CITY OF ALBUQUERQUE

RE: **Lot 33 Block 6 SAD 227**
Unser Cliffs
7912 Kibo NW
Grading and Drainage Plan
Engineers Stamp Date 10/2/17 (E10D039)
Pad Certification Dated 5/25/18

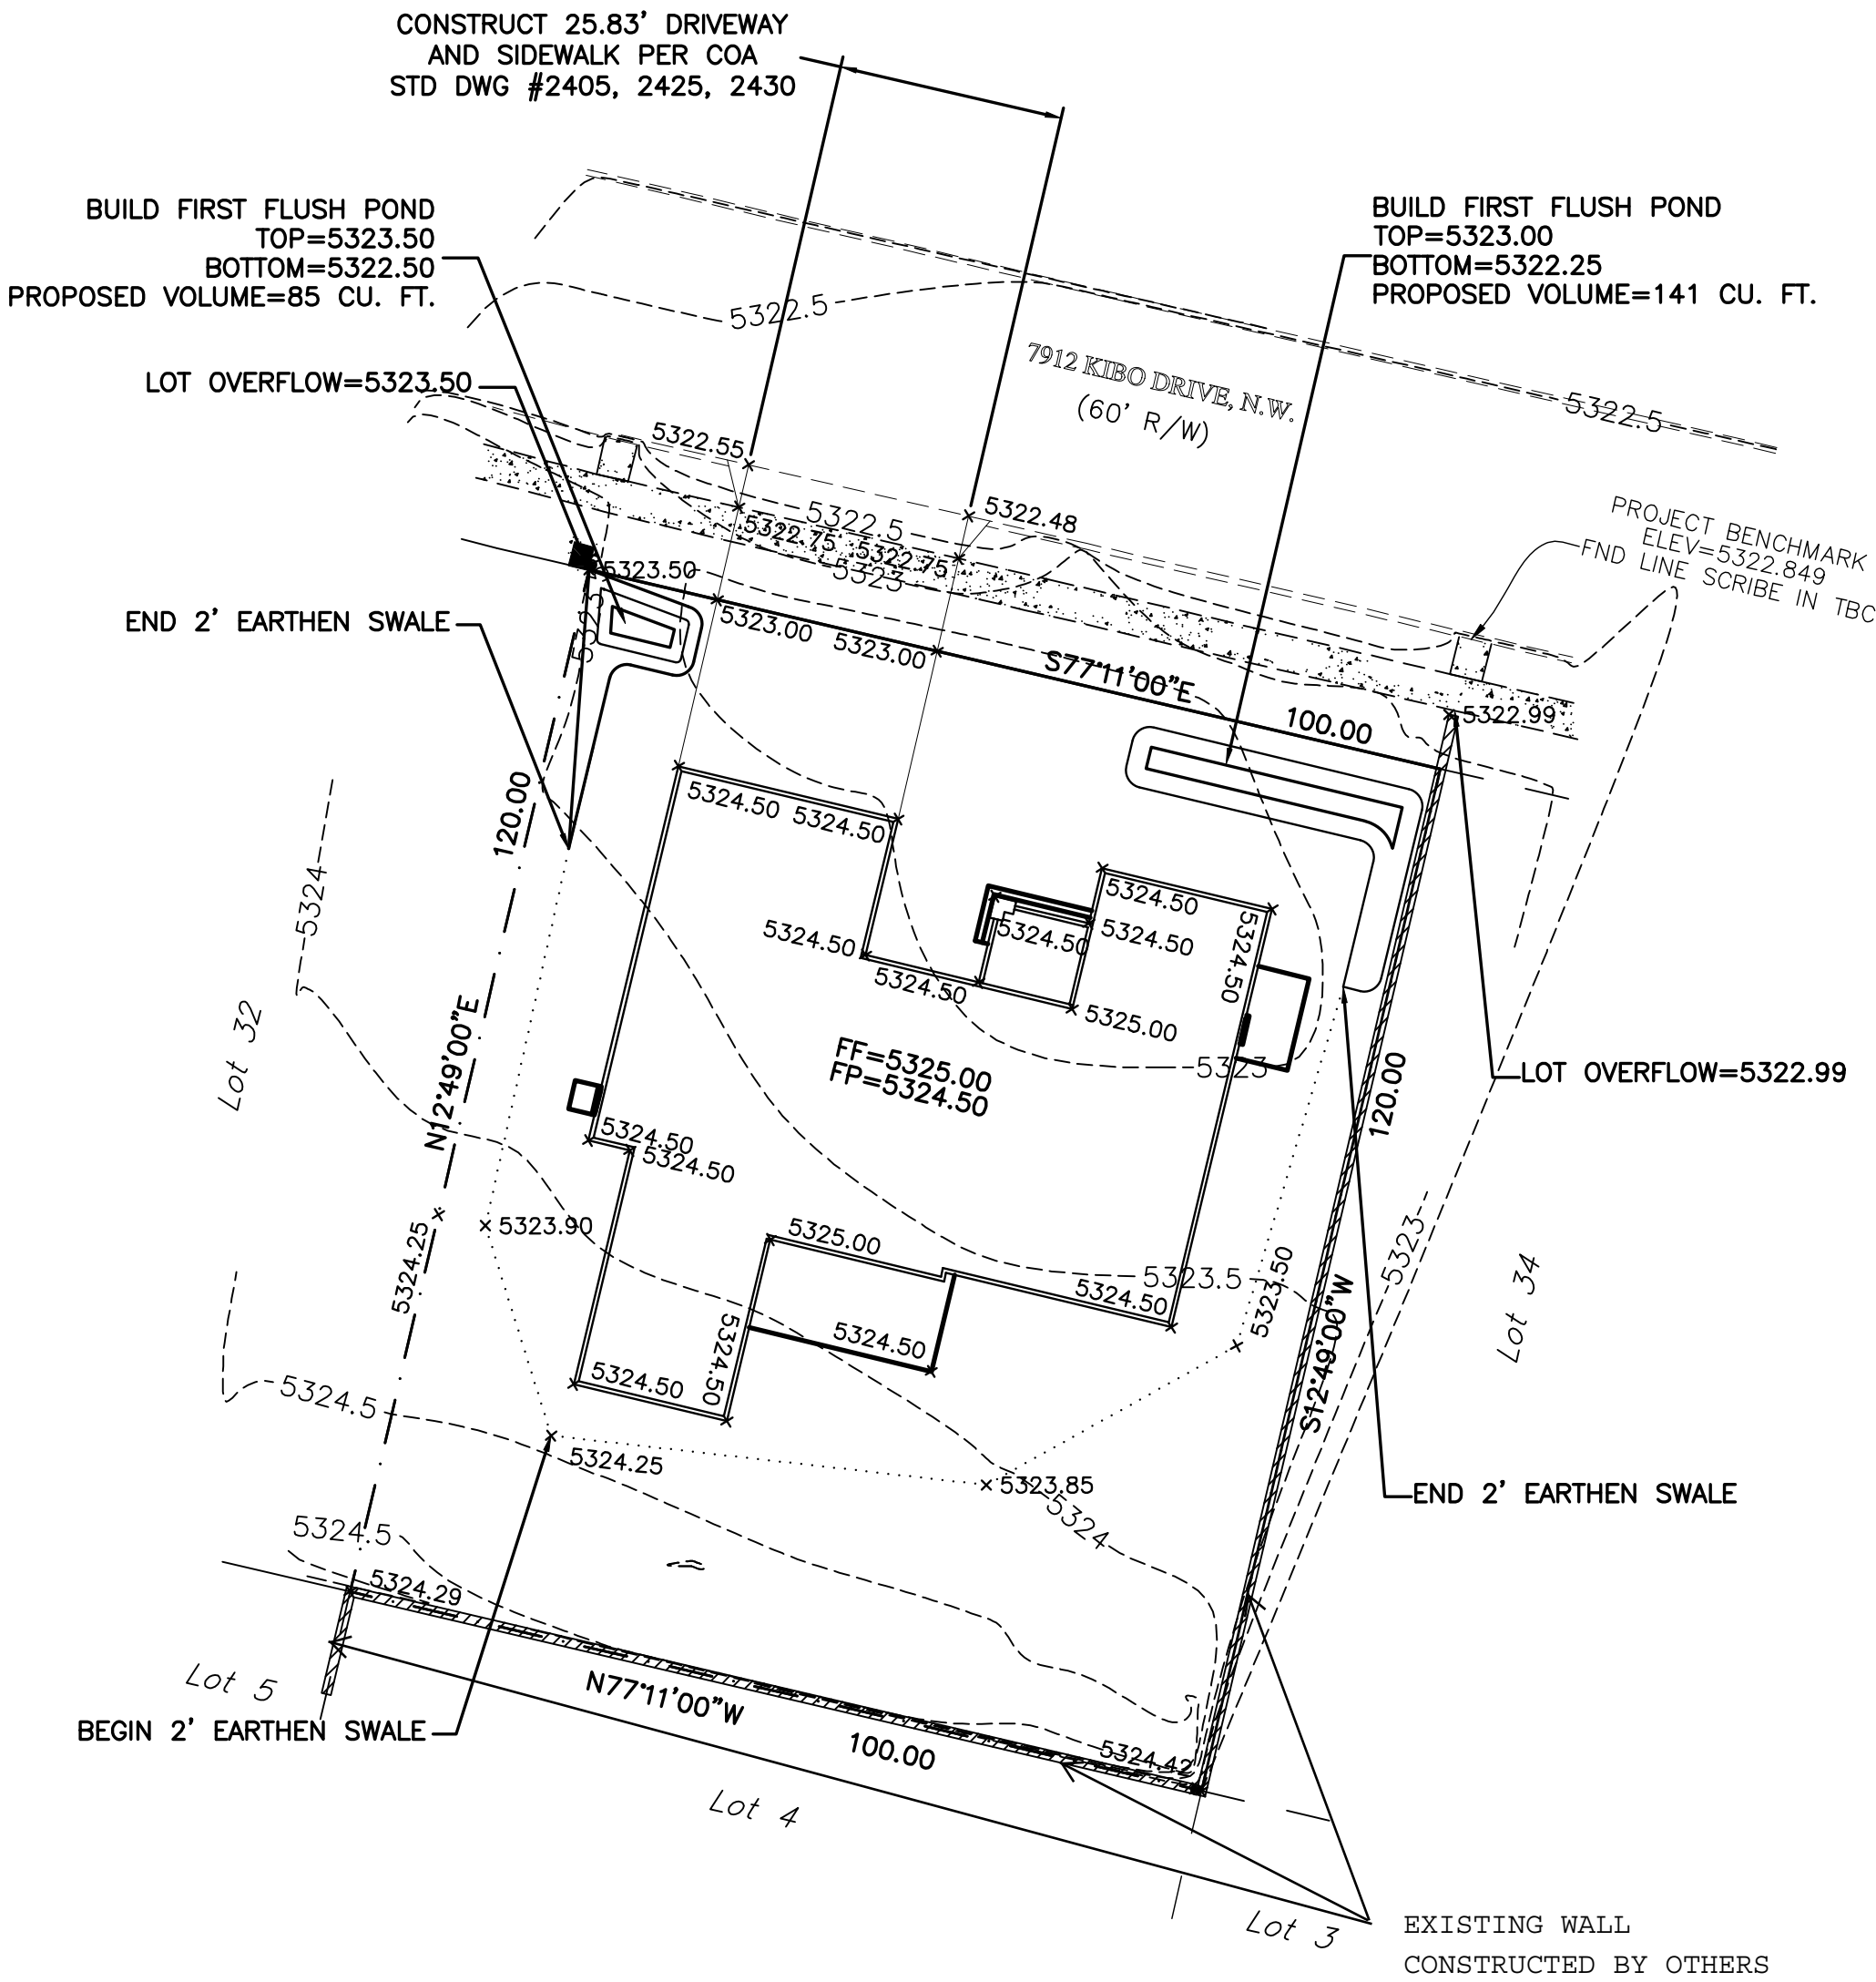
- Provide a statement on the plan stating that this grading plan must be submitted for the application of any garden/retaining walls.
- Provide a cross section of the garden wall, showing that the footings will be inside the property line. Or provide a statement/s from the property owner/s accepting that part of the footing will be located on their property/s.
- Also provide a statement as to why the garden wall is extended into lots 4 & 5 to the south and a letter of acceptance from each owner.
